Ribble Valley Borough Council  
Housing & Development Control

Your ref: 3/2024/0096  
Our ref: D3.2024.0096  
Date: 22<sup>nd</sup> March 2024

Application no: **3/2024/0096**

Proposal: **Proposed replacement boundary fencing using 2.0m/2.4m high welded mesh fencing. Creation of new vehicular access from Little Lane, two pedestrian gates from Preston Road (non-automated), one automated vehicle and pedestrian gate from Preston Road and one automated pedestrian gate from existing barrier car park area.**

PAPER SIZE: A1	DRAWING NUMBER: BS.23-277-02	REV A
SCALE: -	DATE: December 2023	DRAWN BY MDRH

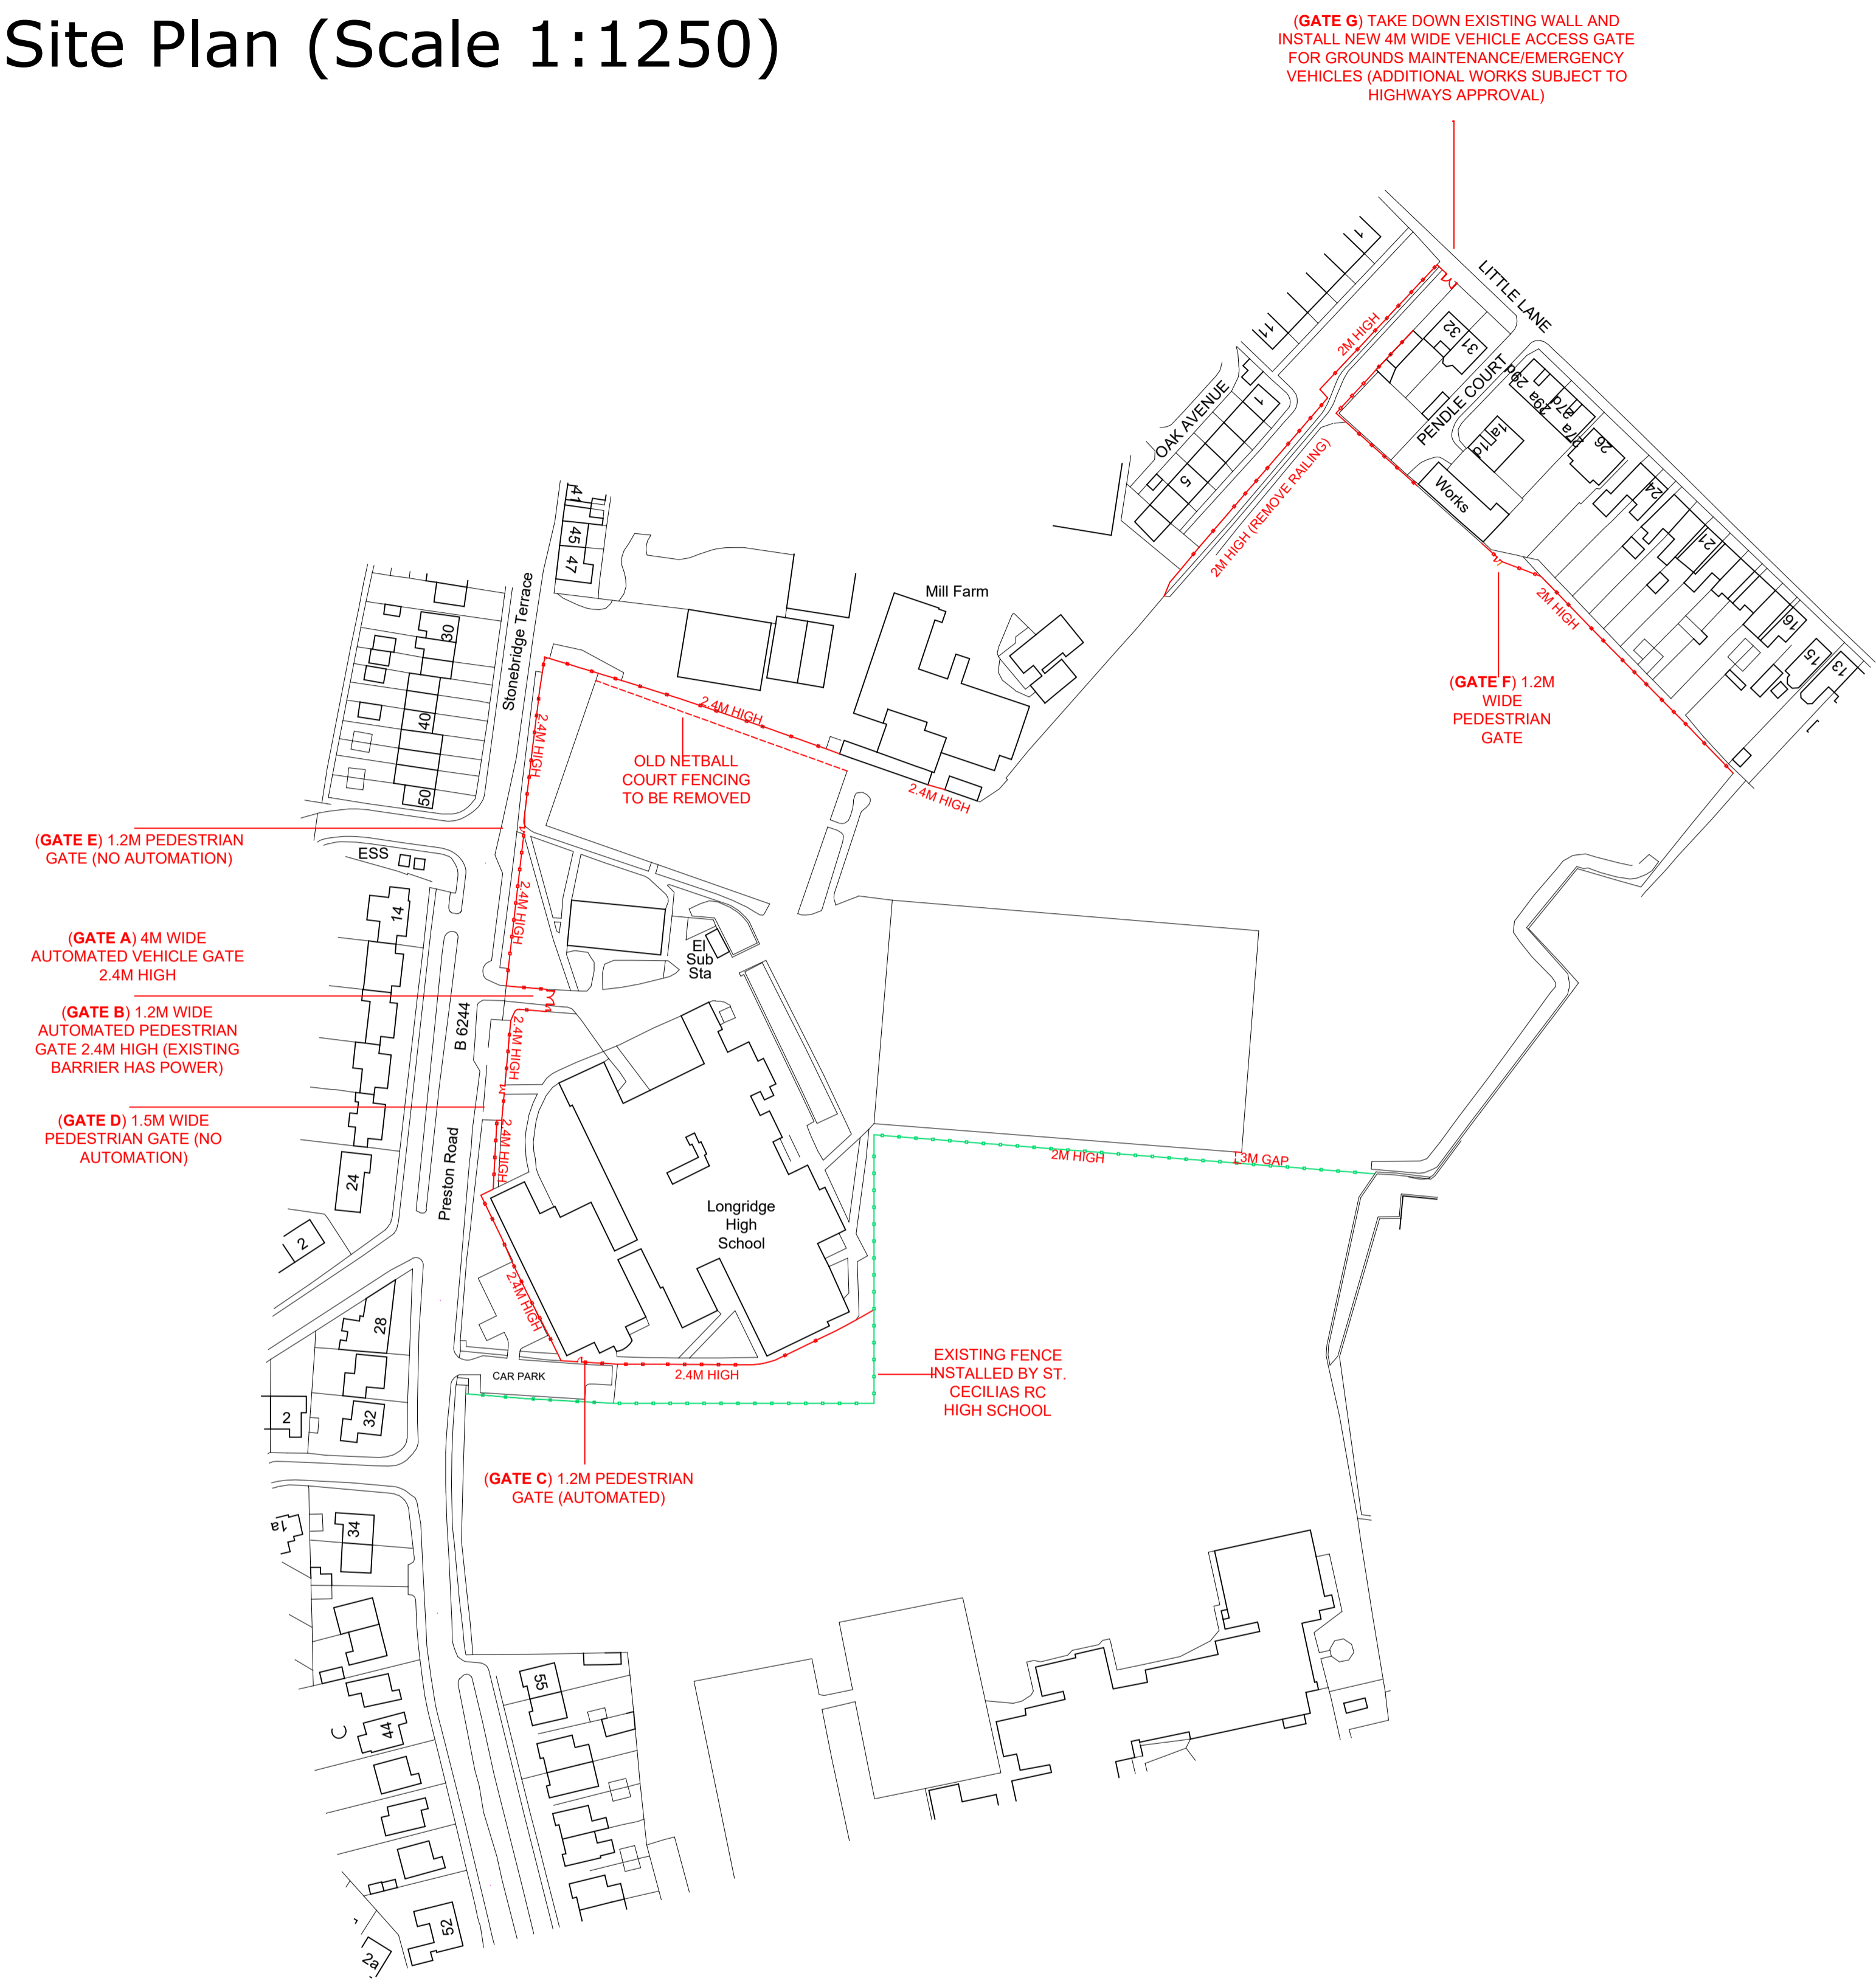
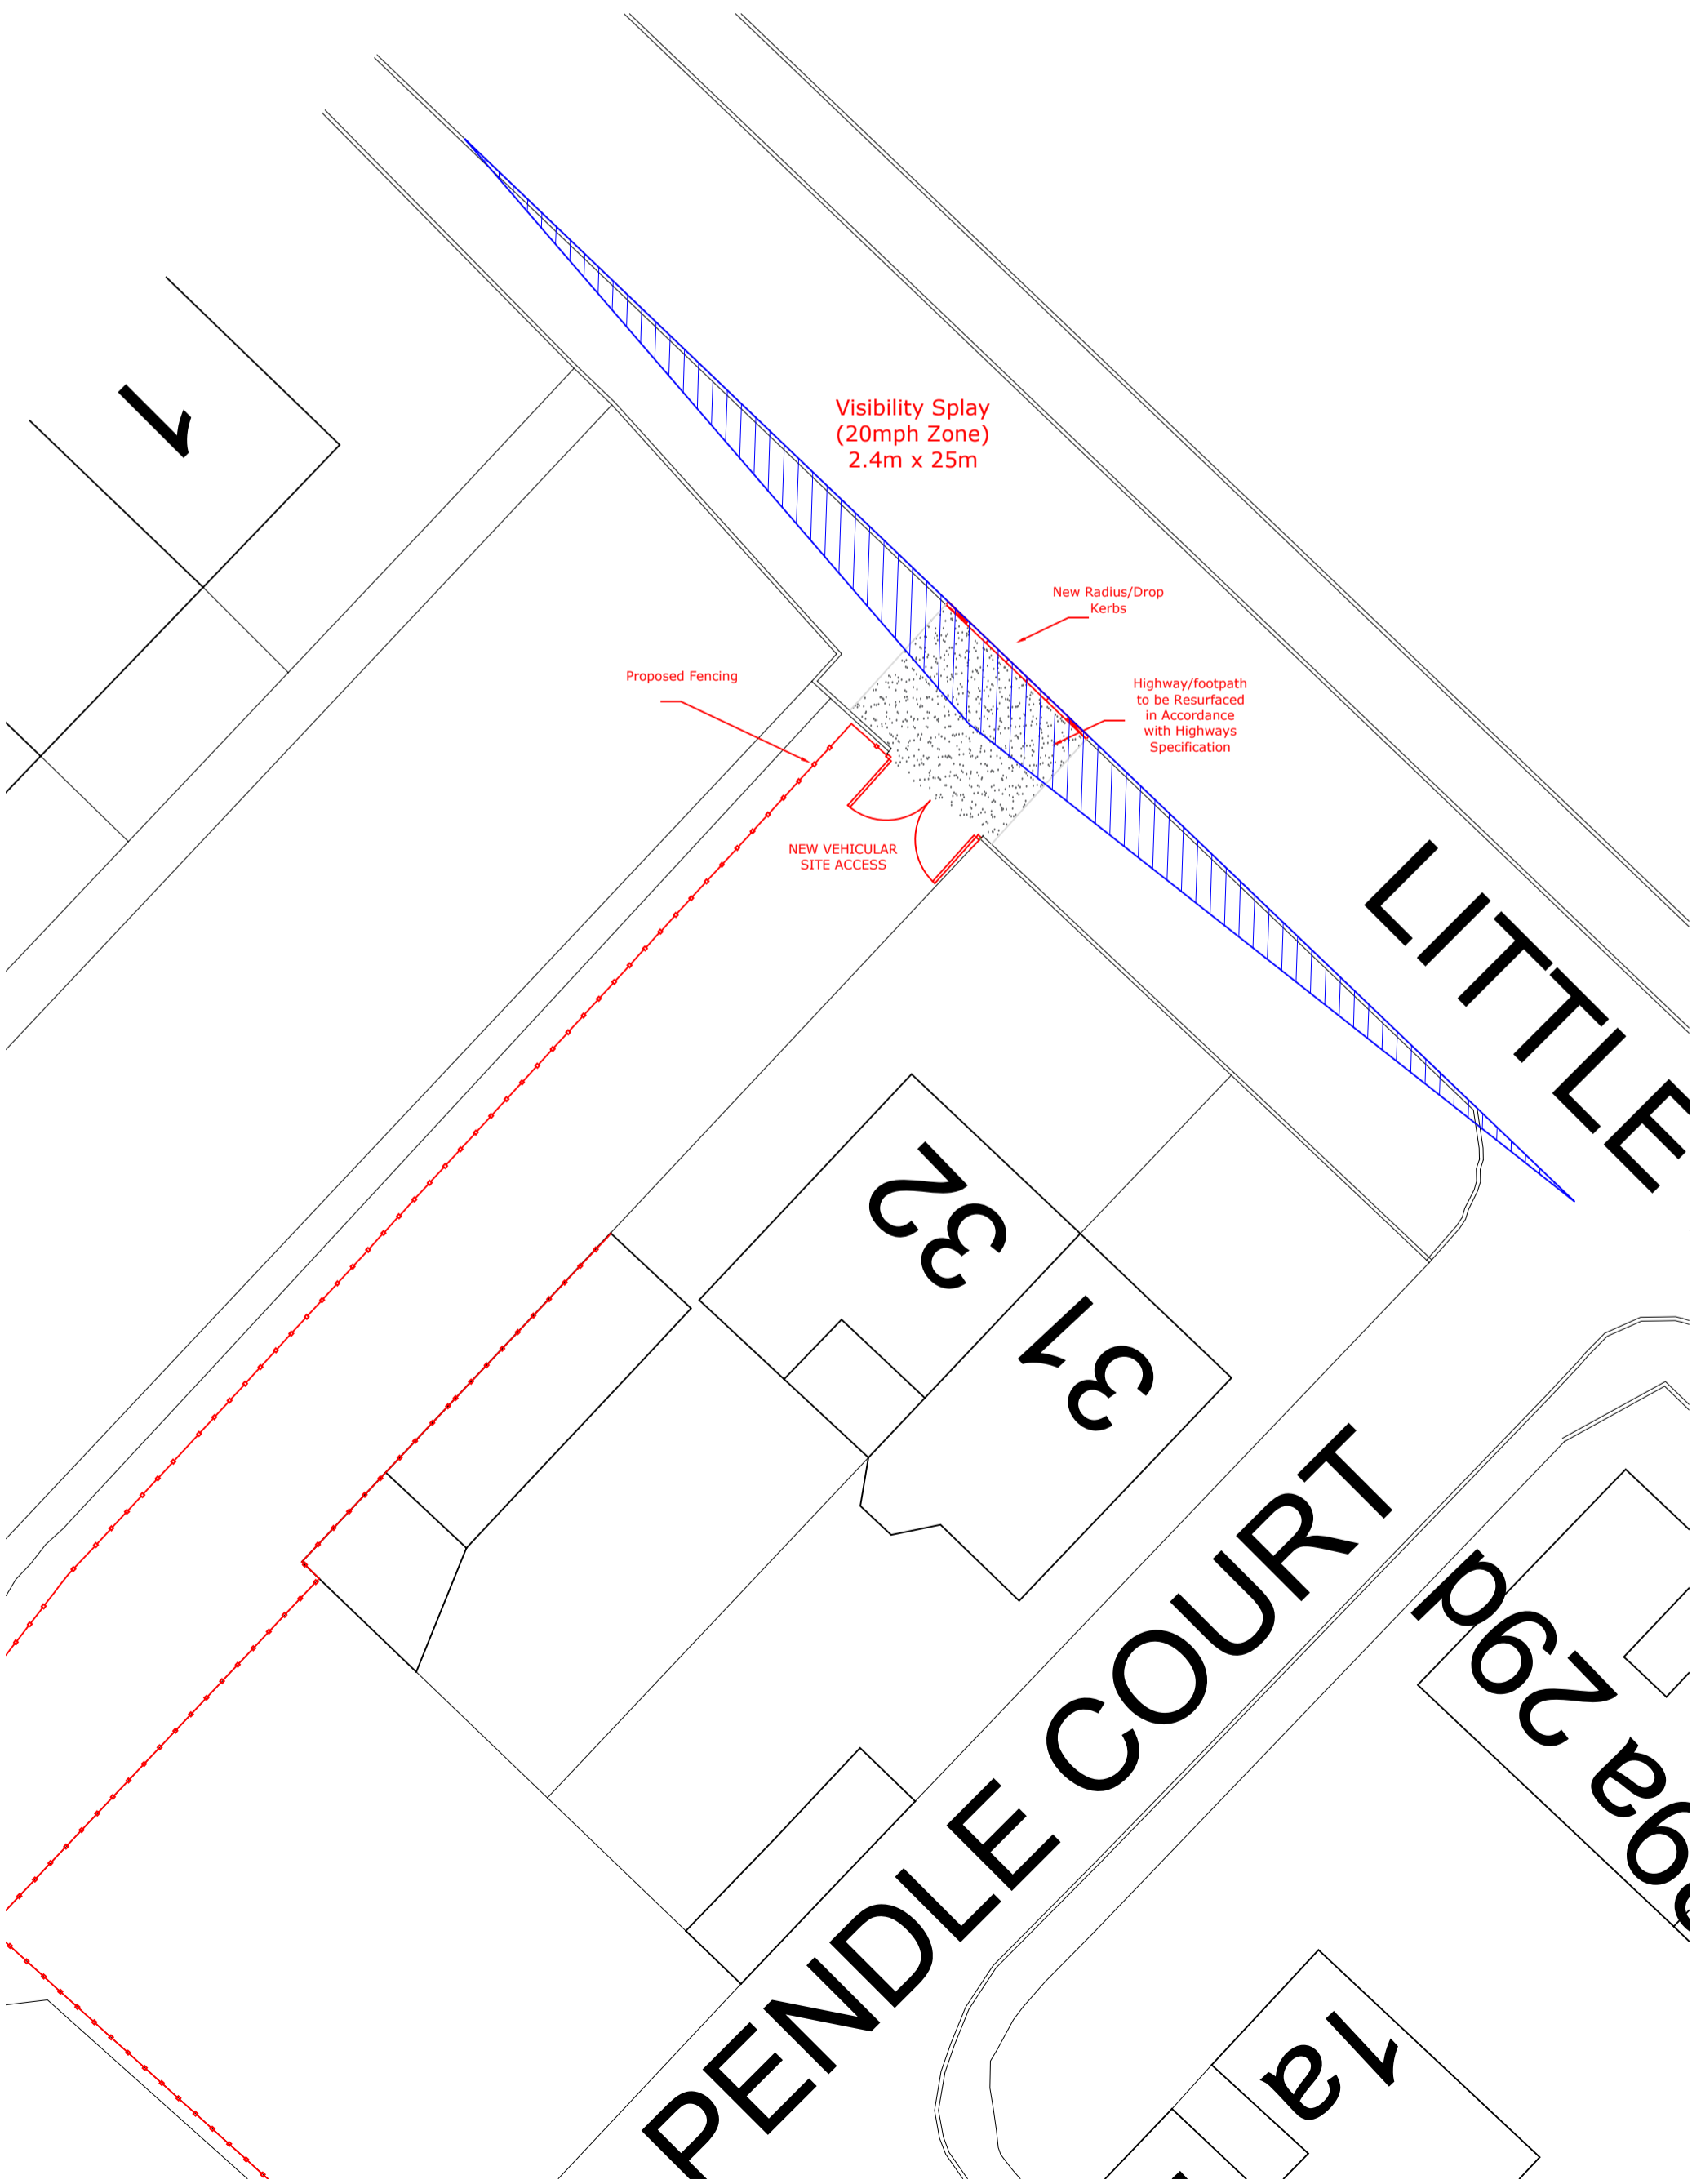
The site will continue to utilise two existing vehicular accesses which are located off Preston Road, a B classified road subject to a 30mph speed limit. The LHA have reviewed Lea Hough drawing number BS-23-277-02 Rev A titled "Site Plan with Proposed Fencing" and have no objection to the proposed replacement boundary fencing around the perimeter of the school. The LHA also have no objection to the replacement or provision of gates to the pedestrian or vehicular accesses which front Preston Road.

However, the LHA do require further information regarding the new vehicular access which will be located off Little Lane, an unclassified road subject to a 20mph speed limit. The site is proposing to provide a 4m wide vehicular access which will be implemented following a dropped kerb application. The new access will only be utilised for ground maintenance with it providing access to the adjacent school field and for emergency vehicles only.

The LHA require further information firstly regarding whether a new access track will be created internally to connect the access fully to the school. Currently, the access track is 5m wide for a total distance of 38m behind the highway boundary, where it appears to eventually reduce in width to 2m and then 1m. Given the use of the access for emergency vehicles, the LHA would expect that the access track reaches the school.

Should there be no vehicular access link to the school enabling vehicles to exit the area via Preston Road, the LHA will require an internal turning area to be provided to allow emergency and maintenance vehicles to exit the access in a forward gear. The LHA will require the Agent to provide a swept path drawing showing that the turning area is suitable for a fire tender or for the largest maintenance vehicle. This drawing needs to be submitted to the LHA for further consideration, with the LHA unable to accept any reversing out onto Little Lane for highway safety reasons.

Furthermore, the LHA require further information regarding the size and the frequency in which maintenance vehicles will use the access along Little Lane. Should the access be used quite frequently, which will be assessed following an Operation Statement being submitted, the LHA will require the gated access to be setback as a minimum the maximum length of the largest maintenance vehicle from the adopted highway. This is to ensure that vehicles will not obstruct the operation of the carriageway when the gates are being operated.

The LHA are also aware that the new site access along Little Lane, as shown on Lea Hough drawing number BS-23-277-02 Rev A, will conflict with a BT service chamber located on the footway and potentially the internal access track to the school field may be obstructed by a telegraph pole. Before the LHA can comment whether the access will be allowed a dropped crossing in this location, the LHA require the Applicant to contact BT to discuss the proposal and to see whether the service chamber can be relocated elsewhere. These discussions and agreements with BT need to be evidenced and submitted to support the creation of a new access in this location.

To prevent needing to contact BT and potentially paying for any costs associated with the relocation of the service chamber or the telegraph pole, the LHA advise that the new access is provided off Pendle Court. This can be provided by connecting the access to

the carriageway where it currently terminates and then the access can be used to connect to the adjacent school field. Should this approach be taken, the LHA will still require an internal turning area to be provided along the access track and further information will still be required in the guise of an Operation Statement.

- Revised site location plan showing this area within the red line boundary of the site.
- Revised site plan.
- Operation Statement regarding the size and the frequency of maintenance vehicles utilising the access.
- Information regarding whether an access track will be created which connects to the school and the provision of an internal turning area to ensure that all vehicles can exit the access in a forward gear.
- Swept path drawing showing that the internal turning area is suitable for the largest vehicle that will use the access. This will be either a fire tender or the largest maintenance vehicle that maintains the grounds associated with the school.
